SUBJECT: Permit Modification Request for TIP No. U-2527, Vance County, Western Outer Loop from SR 1128 (Ruin Creek Road) to SR 1101 (Old County Home Road) near Henderson, Federal Aid No. STP-0509(2), State Project No. 8.2390201, NCDOT Division 5, \$475 Debit WBS Element 34822.1.1.

The purpose of this letter is to request modifications to the CWA Section 404 Individual Permit issued by the USACE, the 401 Water Quality Certification issued by the NC Division of Water Quality (DWQ), and Riparian Buffer Certification issued by DWQ. Revised permit drawings are attached. A revised natural stream design plan is also attached.

NCDOT
DIVISION OF HIGHWAYS
VANCE COUNTY
PROJECT: 8.2290201 (U2527)
HENDERSON WESTERN
OUTER LOOP FROM
SR 1128 TO SR 1101
REV. 06/04
3/16/02

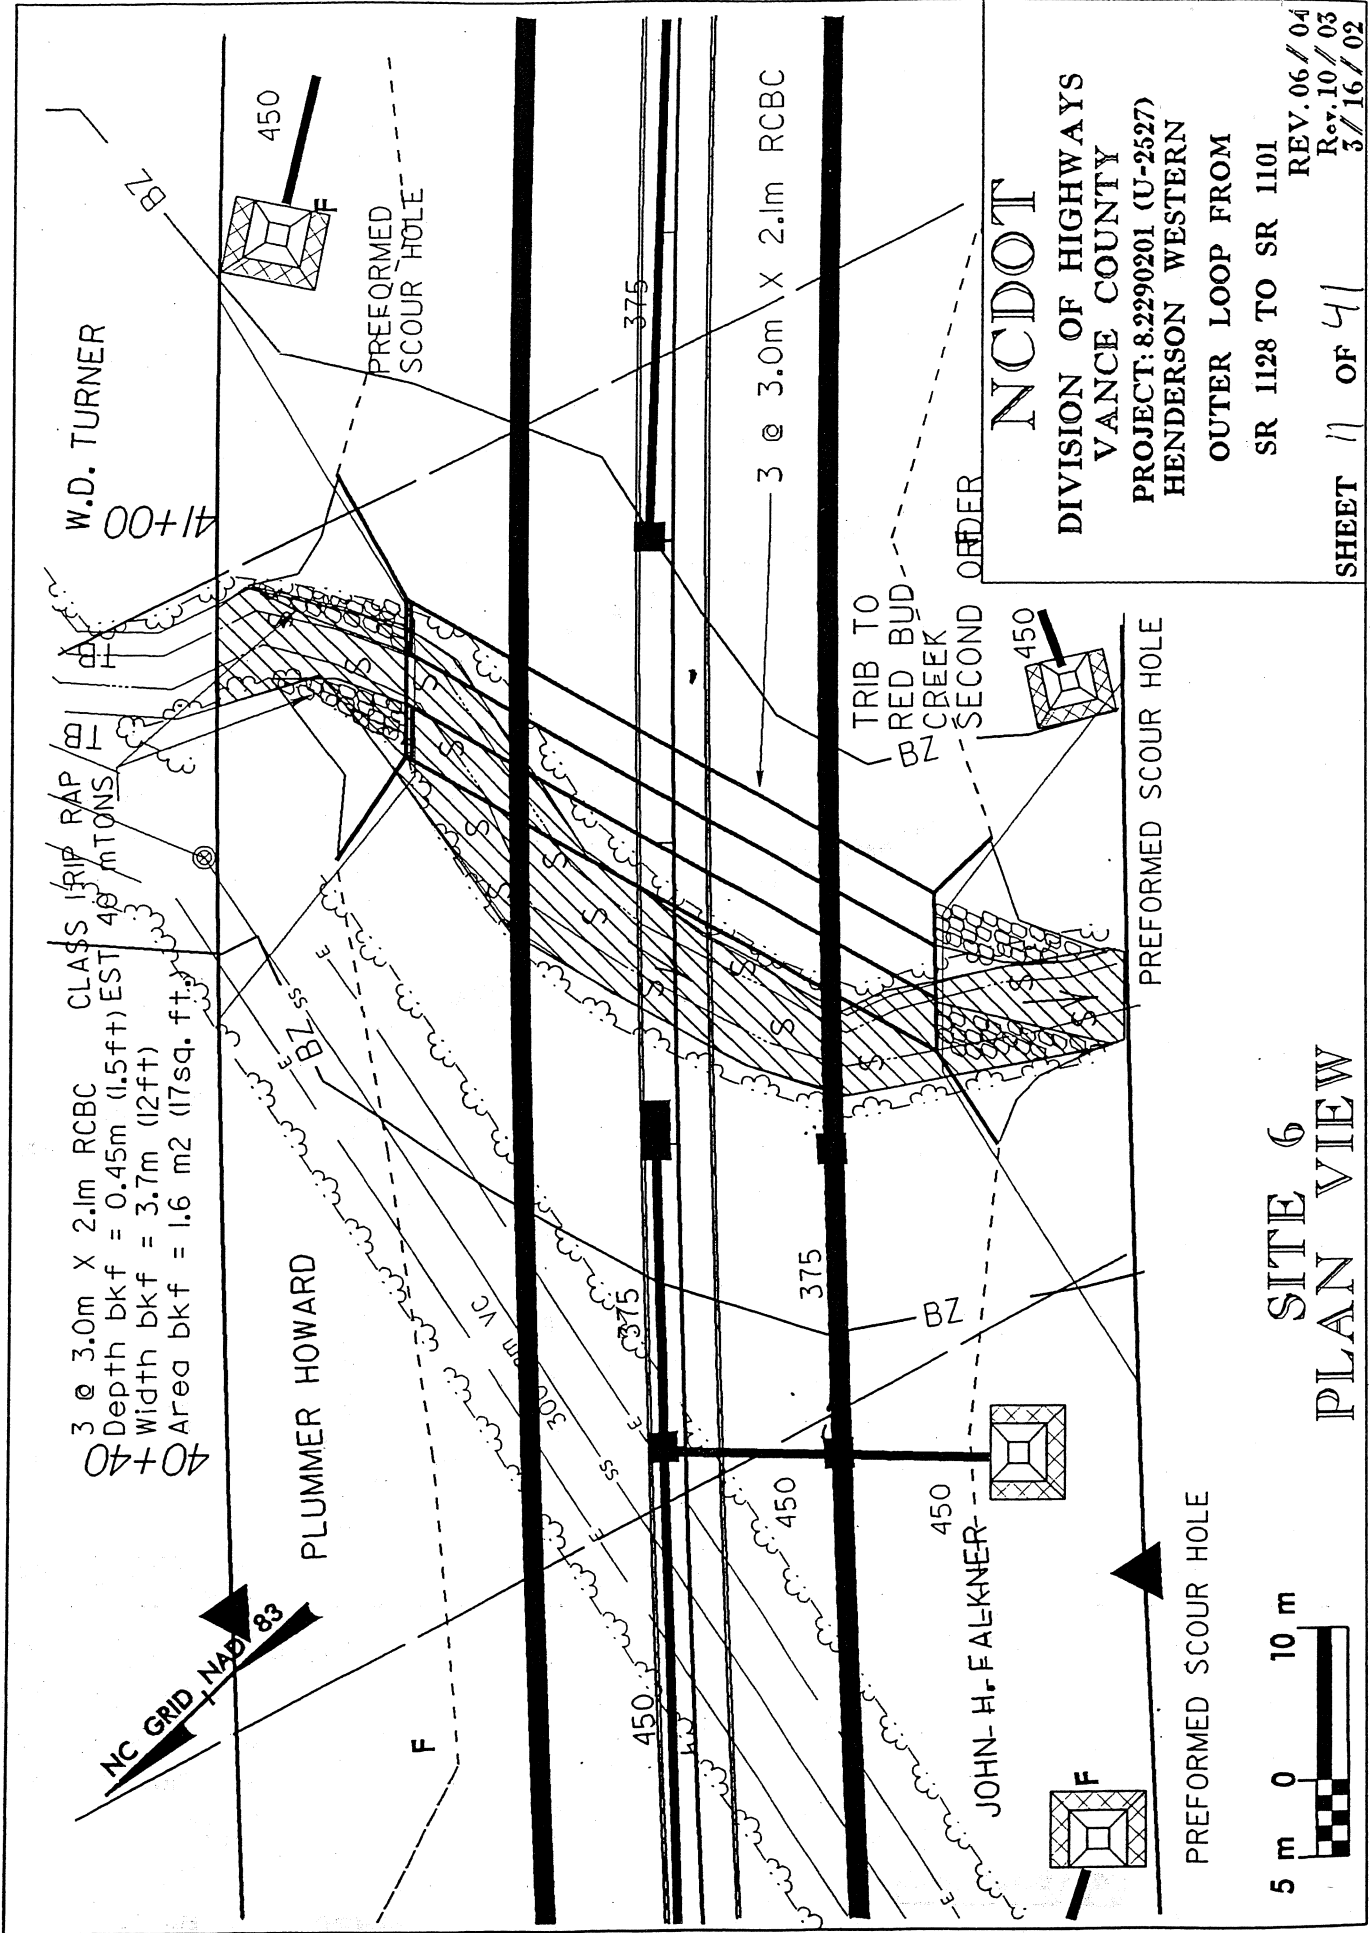
- Stream site 5, buffer site 7 (permit drawing 10 and 29, plan sheet 11, Station 36+72)

Issue: There is a discrepancy in the depiction of the southern fill slope between the permit drawing and the plan sheet.

Issue: The plan sheet depicts the installation of Class I rip rap along the streambank at the outlet of the cross pipe. The permit drawing depicts Class B rip rap at this location.

Issue: The plan sheet indicates the presence of rip rap at the outlet of the structure and lateral base ditches in the northwest and southwest quadrants. The impacts associated with the rip rap and the lateral base ditches are not entirely depicted as buffer impacts on the permit drawing.

Status: The permit drawing has been modified to depict the correct fill slope, size of rip rap and additional buffer impact. **This resulted in an increase of stream impact of 16.4 ft and an increase of riparian buffer impact of 0.02 ac (871.2 square ft) in Zone 2.**

NCDOT
 DIVISION OF HIGHWAYS
 VANCE COUNTY
 PROJECT: 8.2290201 (U-2527)
 HENDERSON WESTERN
 OUTER LOOP FROM
 SR 1128 TO SR 1101
 SHEET 24 OF 41
 REV 06/04
 3/16/02

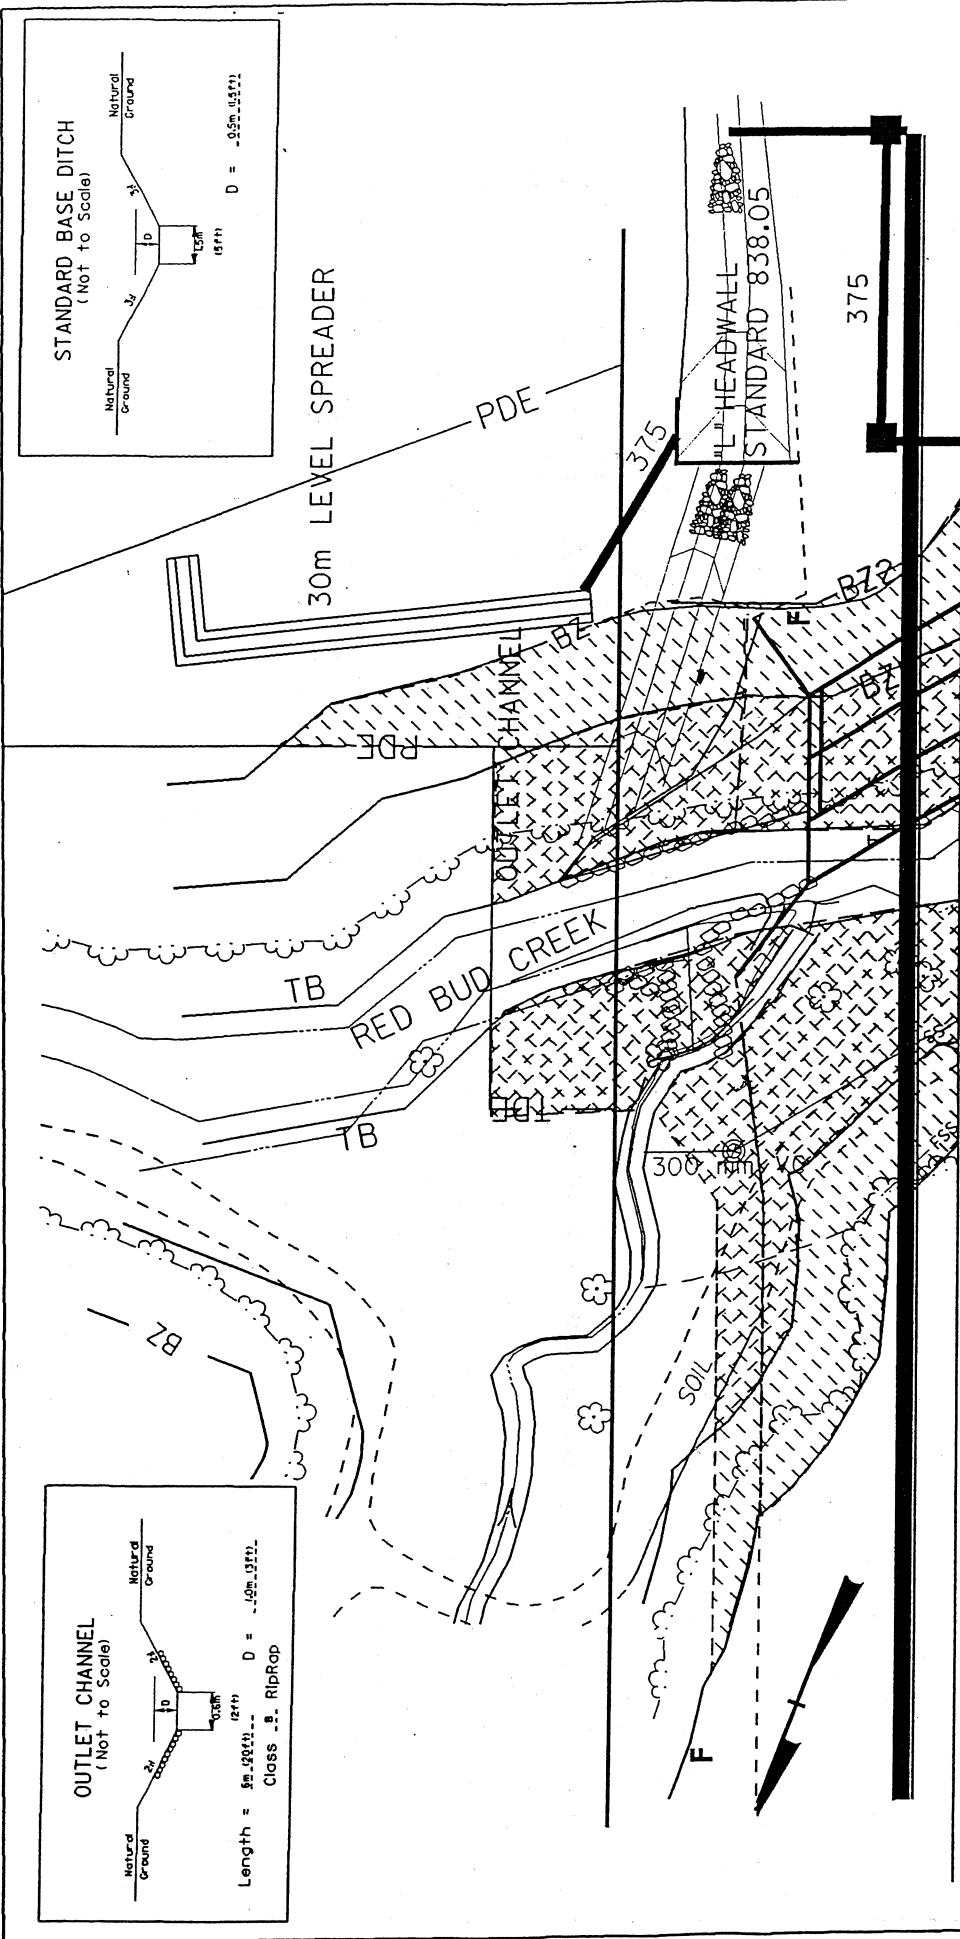
- Stream site 3, buffer site 3 (permit drawing 7, 24, and 25, plan sheet 7, Station 23+40)
 Issue: The plan sheet indicates the presence of rip rap along the northern streambank immediately upstream of the relocated channel at the inlet of the culvert. This rip rap is not depicted on the permit drawing.
 Issue: The plan sheet indicates the presence of a relocated channel, rip rap and a lateral base ditch immediately upstream of the inlet of the culvert. These impacts are not depicted on the permit drawing.
 Issue: The plan sheet indicates the presence of rip rap immediately downstream of the outlet of the culvert. The impact associated with this rip rap is not entirely depicted as a buffer impact on the permit drawing.
 Issue: There is a discrepancy in the depiction of the western fill slope between the permit drawing and the plan sheet.
 Status: The permit drawing has been modified to depict rip rap along the streambank, the additional buffer impacts and the correct fill slope. **This resulted in an increase**

of stream impact of 0.02 ac and an increase of riparian buffer impact of 0.03 ac (1306.8 square ft) in Zone 1 and 0.03 ac (1306.8 square feet) in Zone 2.

NCDOT
 DIVISION OF HIGHWAYS
 VANCE COUNTY
 PROJECT: 8.2290201 (U-2527)
 HENDERSON WESTERN
 OUTER LOOP FROM
 SR 1128 TO SR 1101
 SHEET 27 OF 41
 REV 06/04
 3/16/02

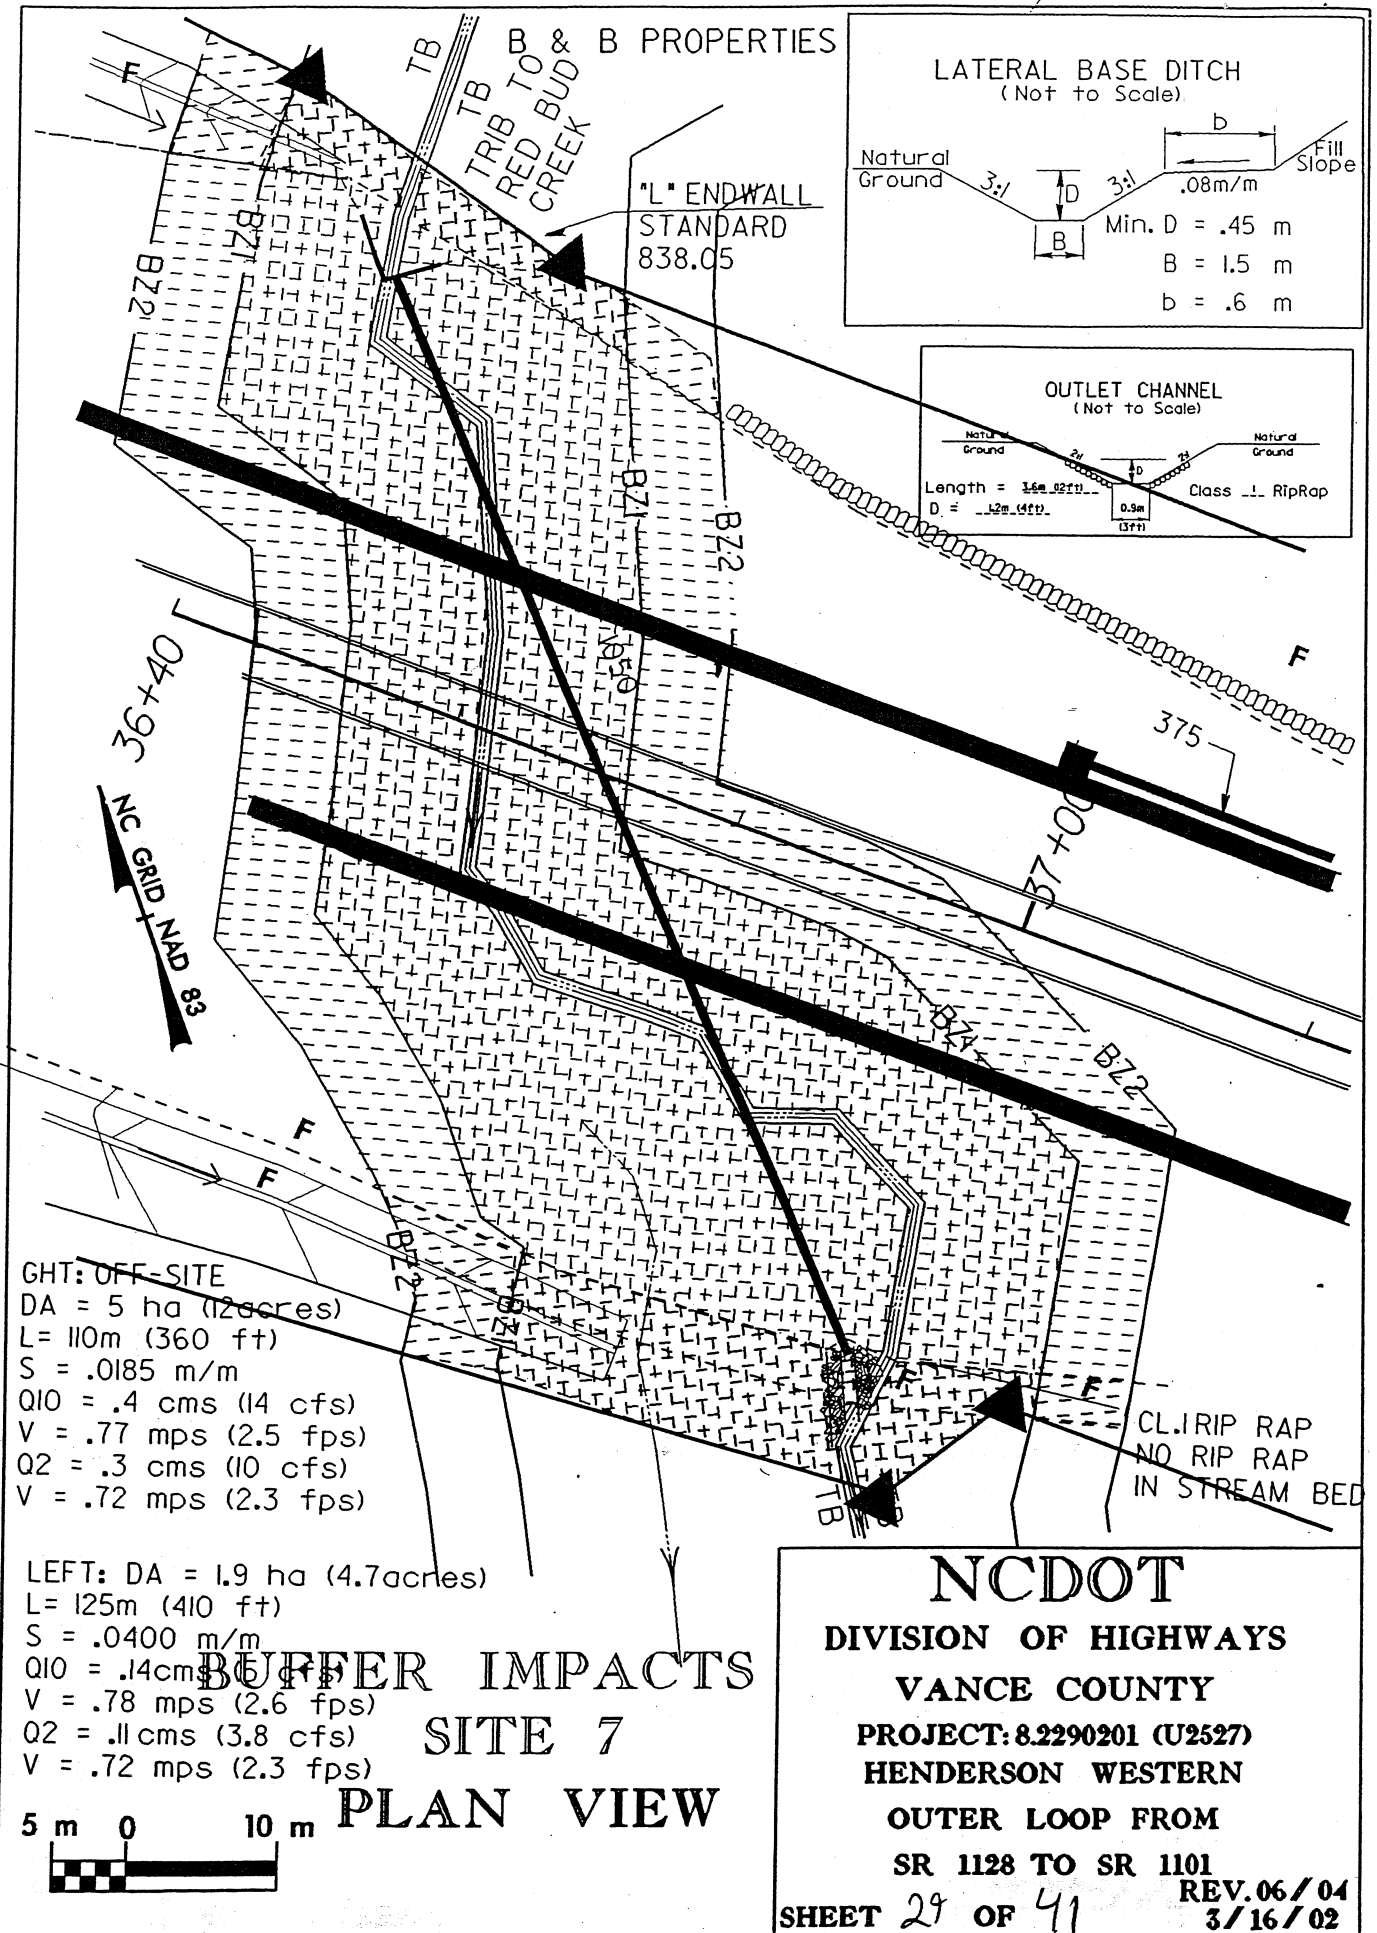
- Stream site 4, buffer site 5 (permit drawing 9 and 27, plan sheet 8, Station 26+00 to 26+30)

Issue: The plan sheet indicates that the cross pipe located at Station 26+58 is a 600mm structure. The permit drawing indicates that this cross pipe is a 450mm structure.

Issue: The plan sheet indicates the presence of a cross vane downstream of the outlet of the structure. The impact associated with the cross vane is not depicted as a buffer impact on the permit drawing.

Status: The permit drawing has been modified to depict the correct size of the structure and additional buffer impact. **This resulted in no change to stream or riparian buffer impacts.**

**BUFFER IMPACTS
SITE 8
PLAN VIEW**

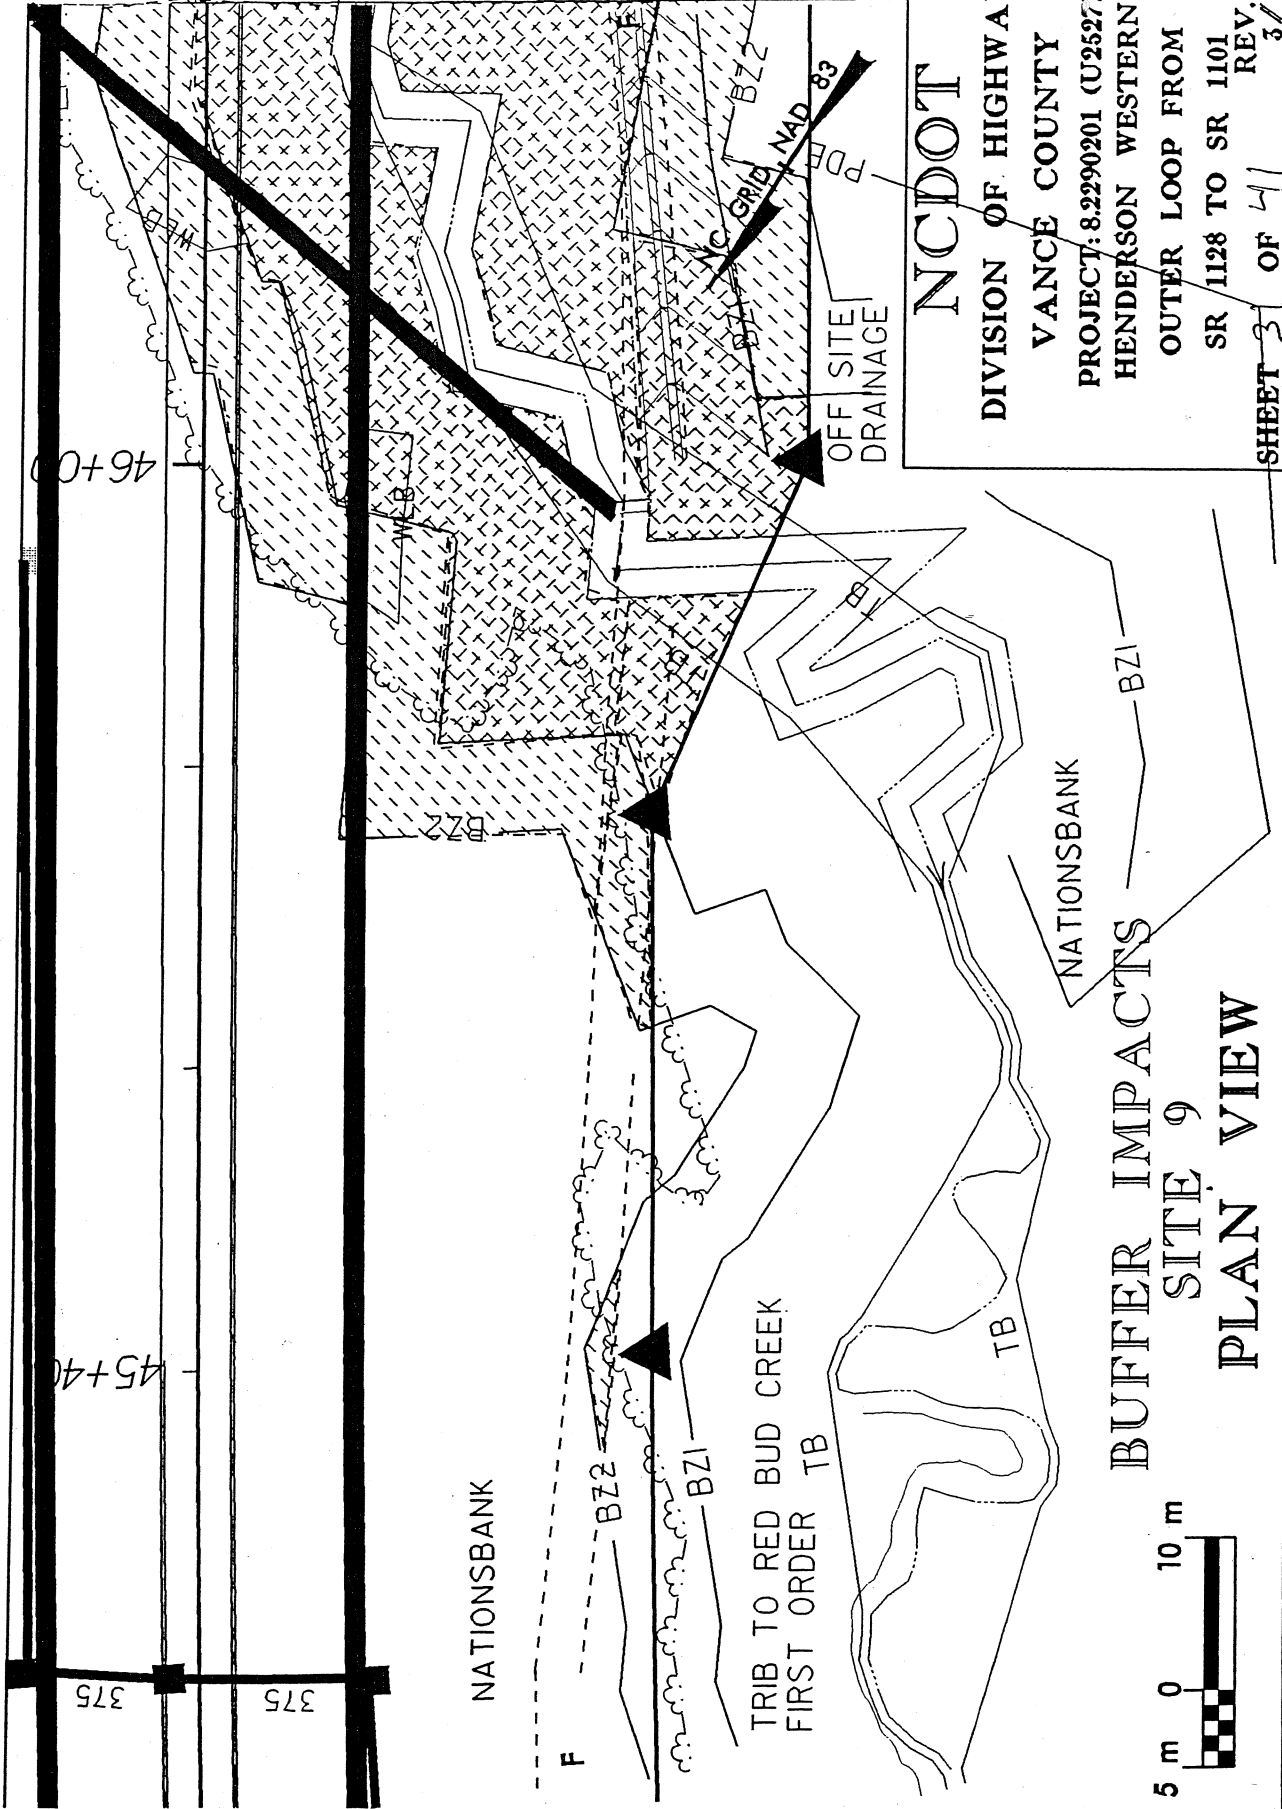
- Stream site 6, buffer site 8 (permit drawing 11 and 30, plan sheet 12, erosion control sheet EC-13, Station 40+81)

Issue: The plan sheet depicts Structure 92 at Station 40+39 Rt and Structure 93 at Station 40+59 Rt. These structures are not depicted on the permit drawing.

Issue: The plan sheet depicts a Preformed Scour Hole (PSH) located outside of the riparian buffer at Station 40+90 Rt. This PSH is located inside of the riparian buffer on the permit drawing.

Issue: The tie in points of the temporary channel change as depicted on EC-13 are located outside of the permitted stream and buffer footprint as depicted on the permit drawing.

Issue: There are slight discrepancies in the depiction of the fill slopes in the northeast, northwest and southwest quadrants between the permit drawing and the plan sheet.

Issue: The plan sheet indicates the presence of rip rap at the inlet and outlet of the structure. The impact associated with the rip rap is not entirely depicted as buffer impacts on the permit drawing.

Status: The permit drawing has been modified to depict structures, the correct location of the PSH, revised stream impact, revised buffer impact, additional buffer impact and the correct fill slope. **This resulted in an increase of stream impact of 9.9 ft.**
